SSD 7542 – RPA MULTI-STOREY CAR PARK PROJECT – EIS

MIKE SHARPIN
Acting Manager, Metropolitan Infrastructure
NSW Environment Protection Authority

ATTACHMENT A
- ENVIRONMENT PROTECTION AUTHORITY COMMENTS -
RPA MULTI-STOREY CAR PARK

Background Noise Logging Results

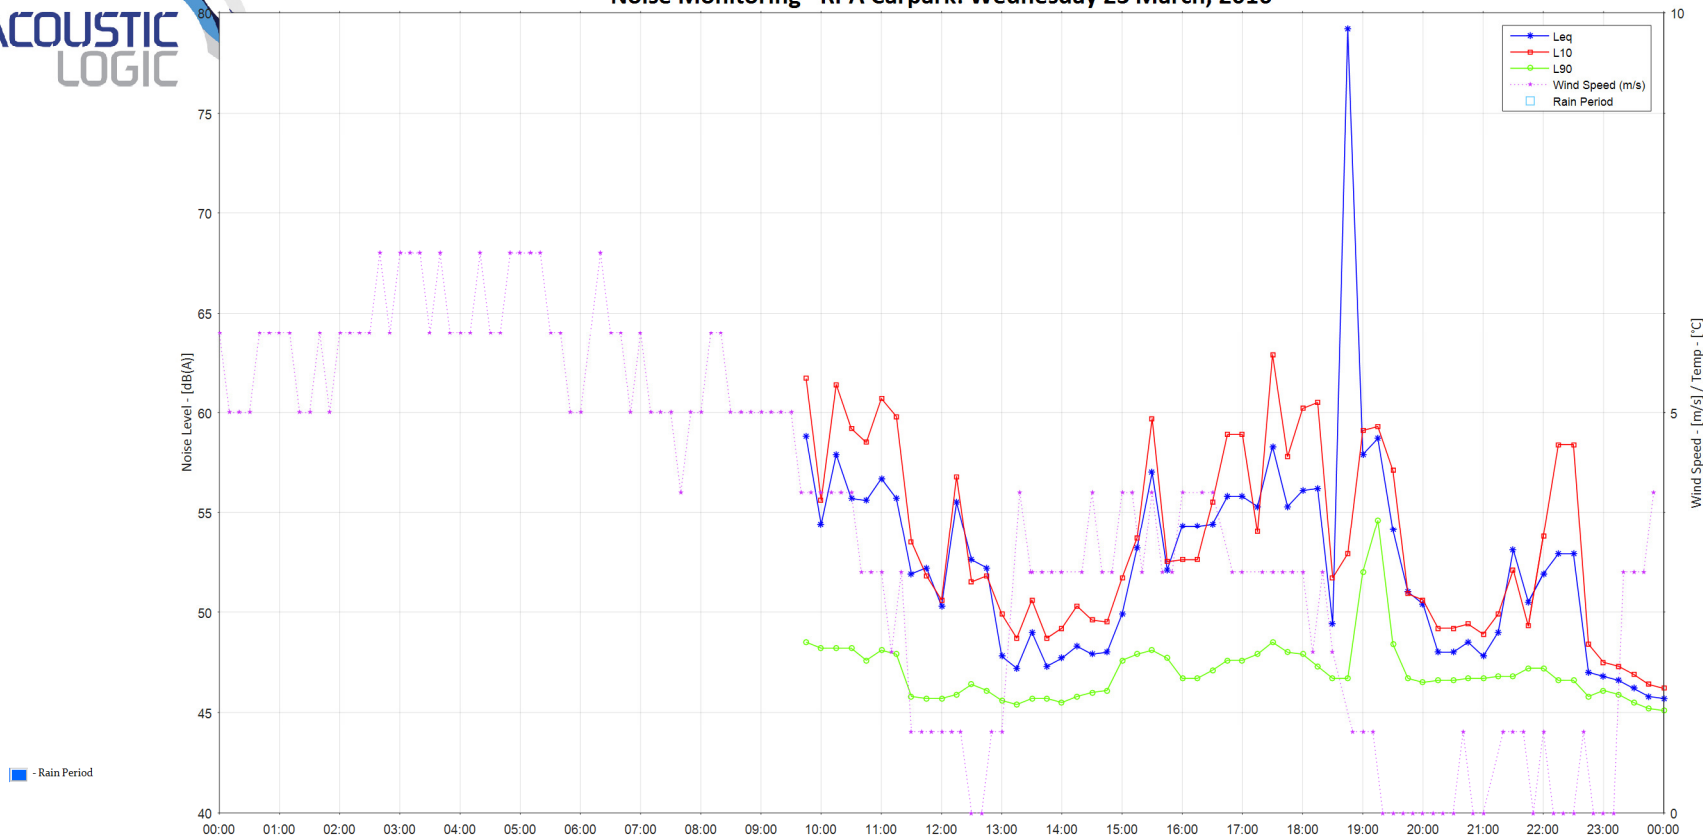
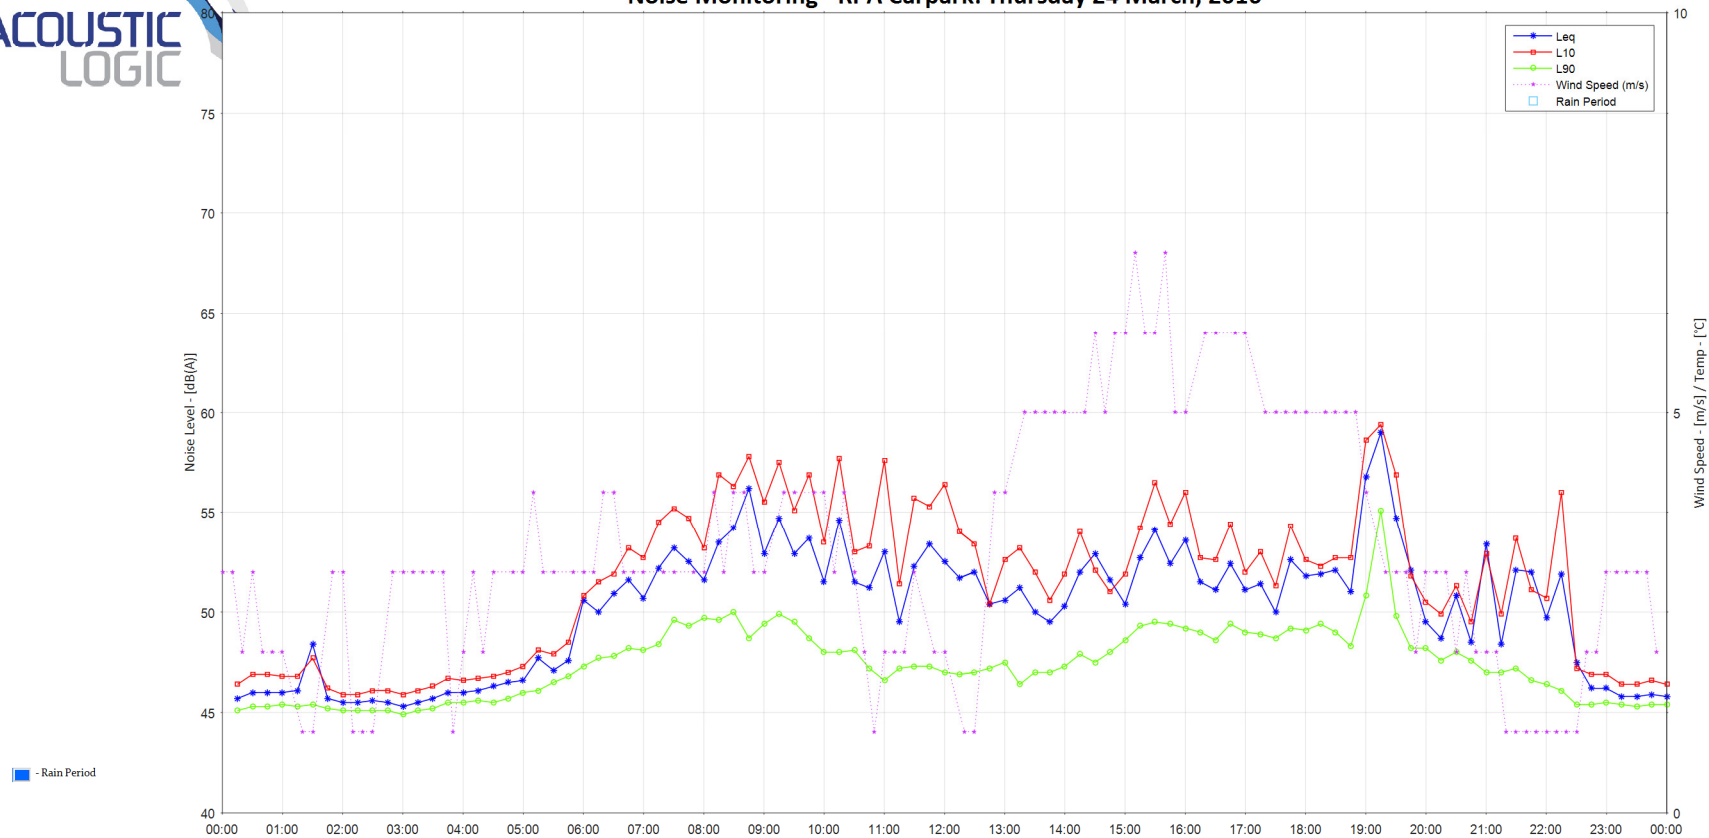
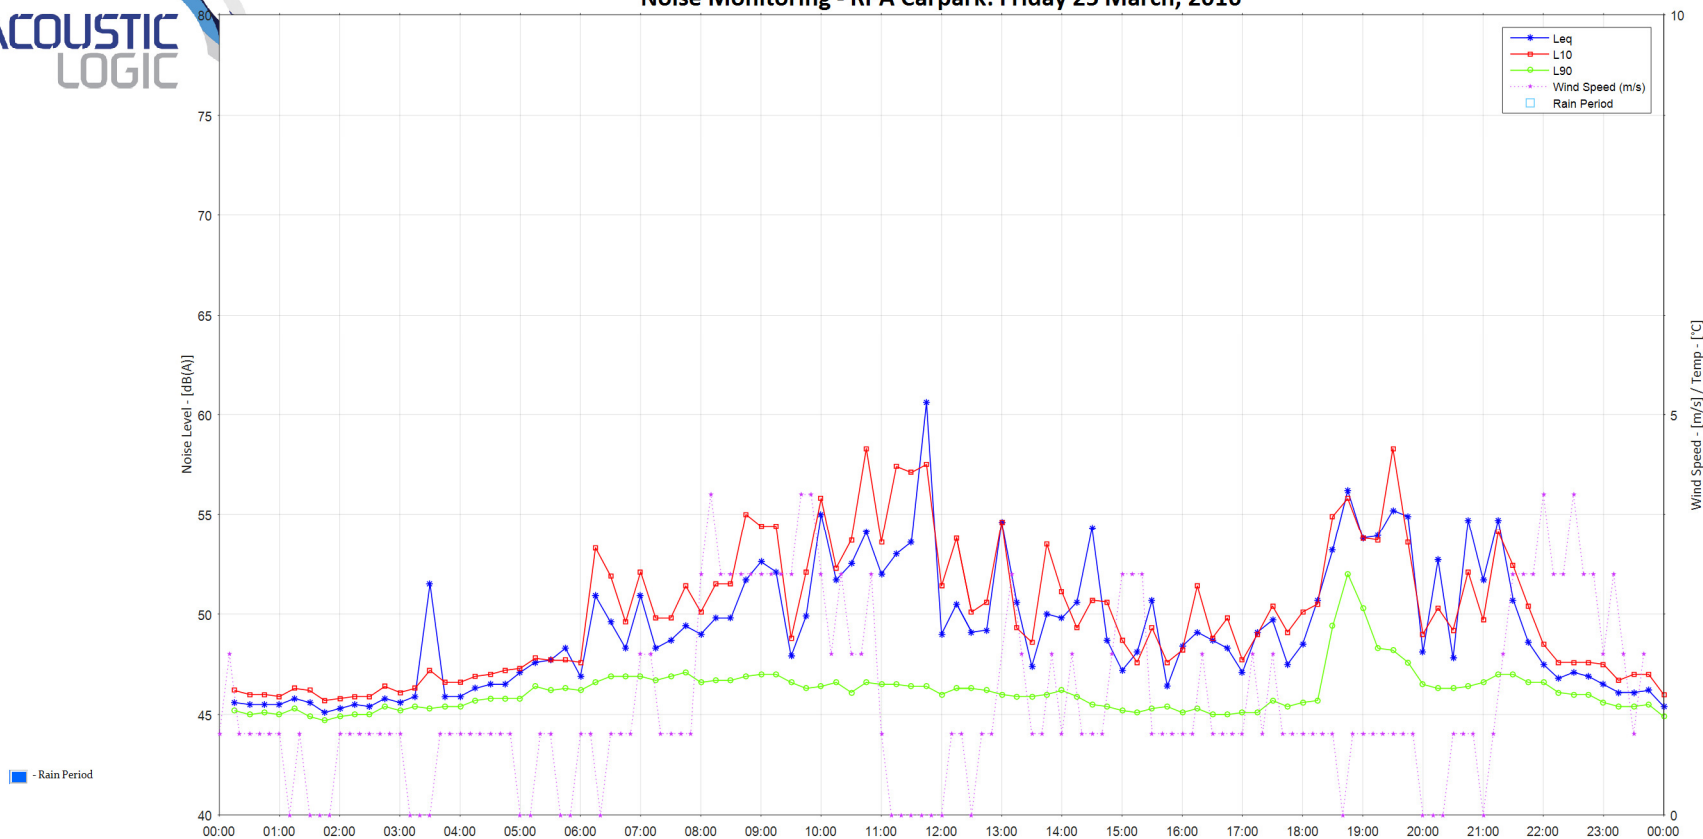
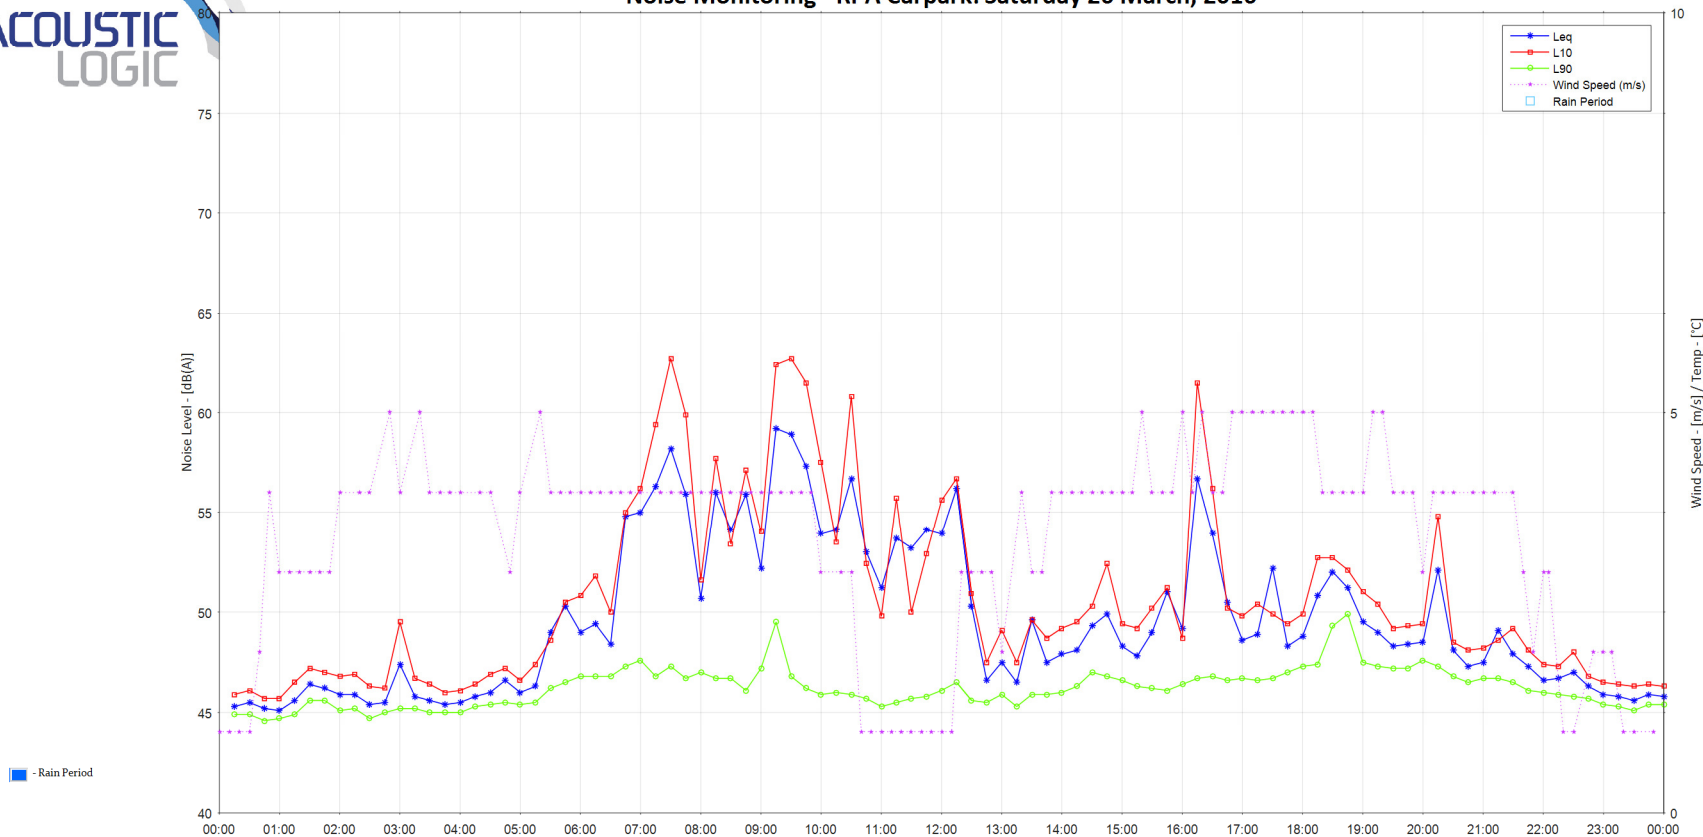
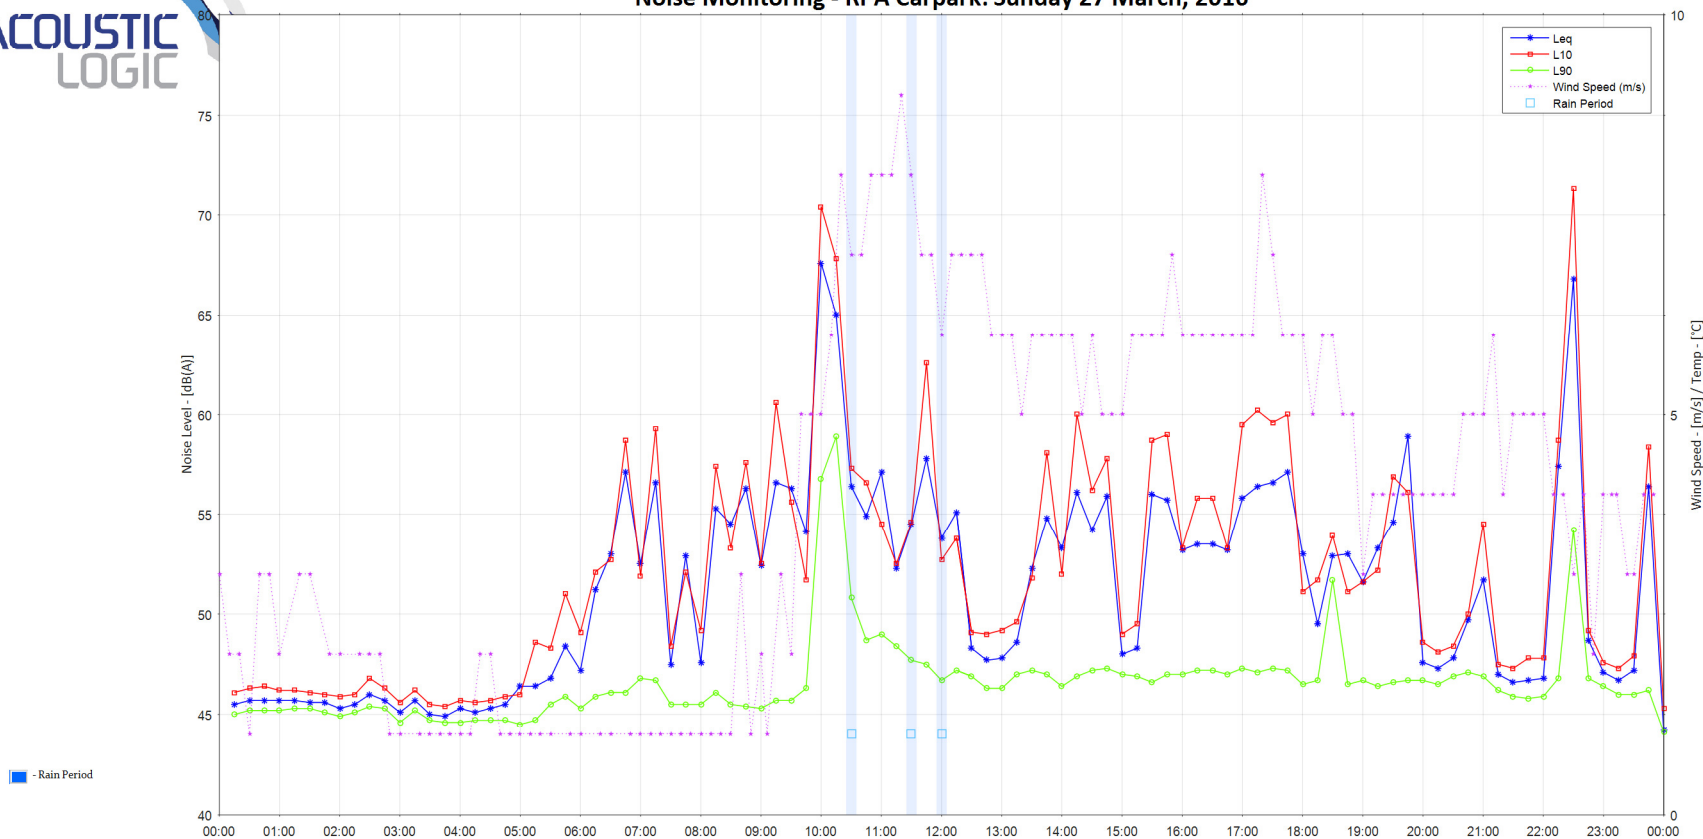
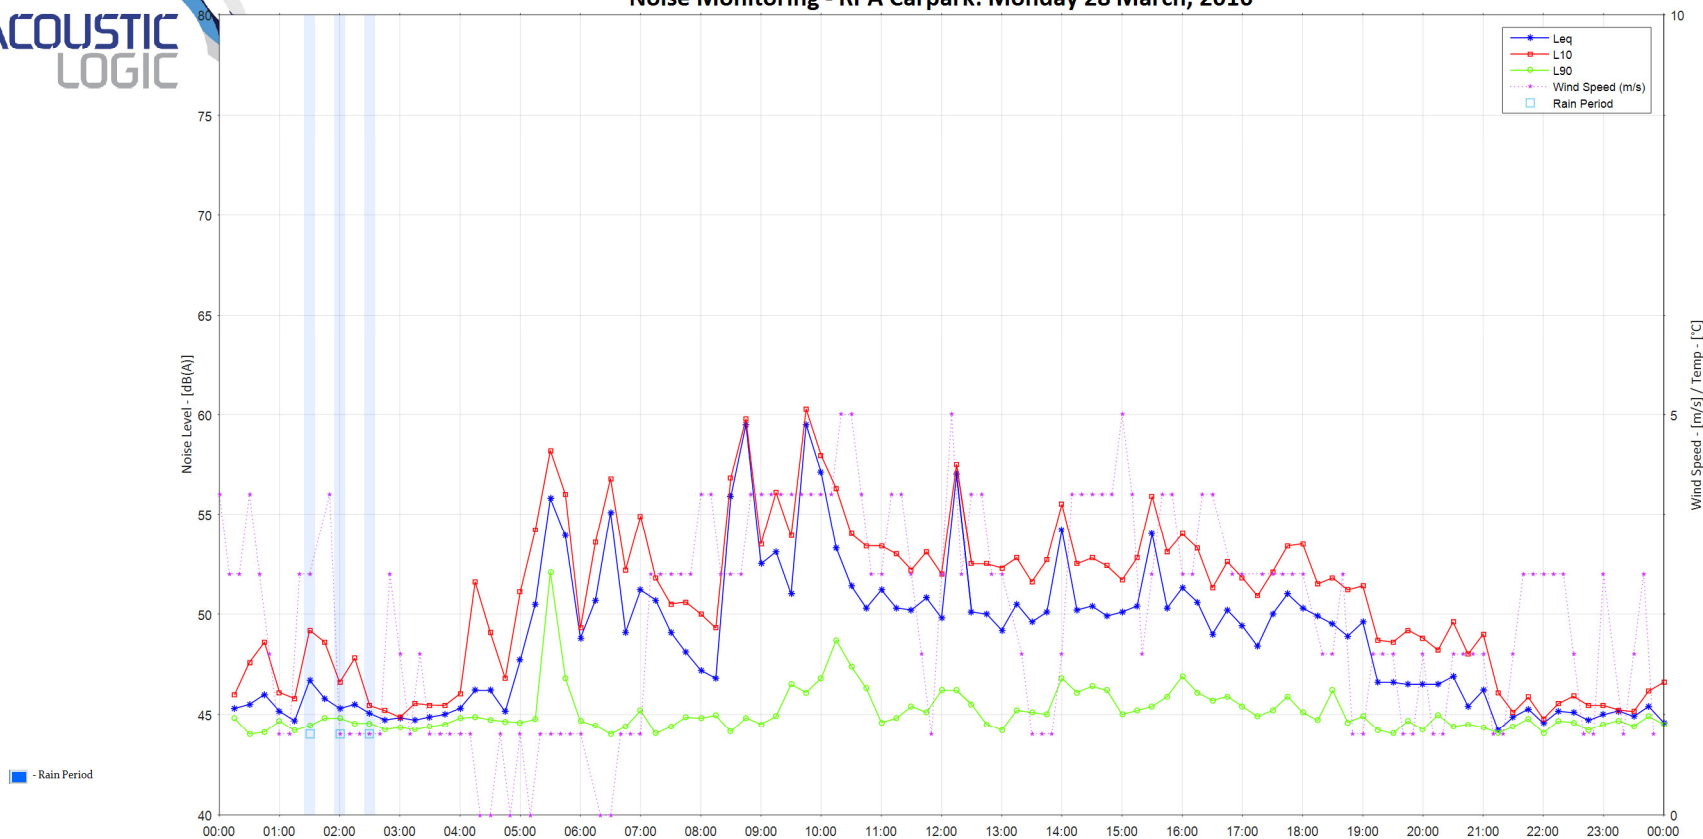
The EPA is similarly concerned that the proponent does not appear to have obtained the minimum "... one week's worth of valid data ..." anticipated by the INP for the assessment of the background noise levels (i.e. for day, evening and night-time periods), particularly given that –

- (i) no background noise monitoring data is presented until 10.00 am on 23 March 2016 (noting that wind speeds are reported as 5 metres per second or greater prior to 10.00 am);
- (ii) no background monitoring data is recorded for 30 March after 8.00 am and contrary to section 4 (2nd para) of EIS Appendix O background noise monitoring data was not presented for 31 March 2016; and
- (iii) the Bureau of Meteorology (Observatory Hill) recorded rain on 4 of the 8 days of the background monitoring period with highest daily rainfall of 34.8 mm and 7.0 mm observed on 28 and 30 March respectively. However, the rain periods shown on the background noise monitoring graph for 28 March 2016 do not appear to be consistent with the Bureau of Meteorology observations.

The INP allows noise measurements made under adverse meteorological conditions when it can be demonstrated that wind-induced noise on the microphone (and sound levels due to rain) is at least 10dB below the noise levels under investigation. However, the noise impact assessment does not provide any demonstration that wind-induced noise and rain noise was at least 10dB below the noise levels under investigation. Instead, the proponent notes in section 4 (5th para, p.8) of EIS Appendix O that wind and rain affected monitoring data have "... been omitted when determining the background noise levels at the site."

However, the EPA would consider it reasonable to adopt a night-time background noise level of 40 dBA, to ensure the noise objectives are adequately protective, particularly in regard to sleep disturbance.

- (a) (i) to adopt a night-time background noise level of 40 dBA, OR
- (ii) provide a quantitative assessment of the 'night-time' background noise level measured at the most affected residence (corner of Fowler and Church Streets and in accordance with the guidance material provided in the New South Wales Industrial Noise Policy. And, identify the dominant and background noise sources present at the site throughout the monitoring period (including "identification and occurrence of noise sources" in accordance with INP B1.2)
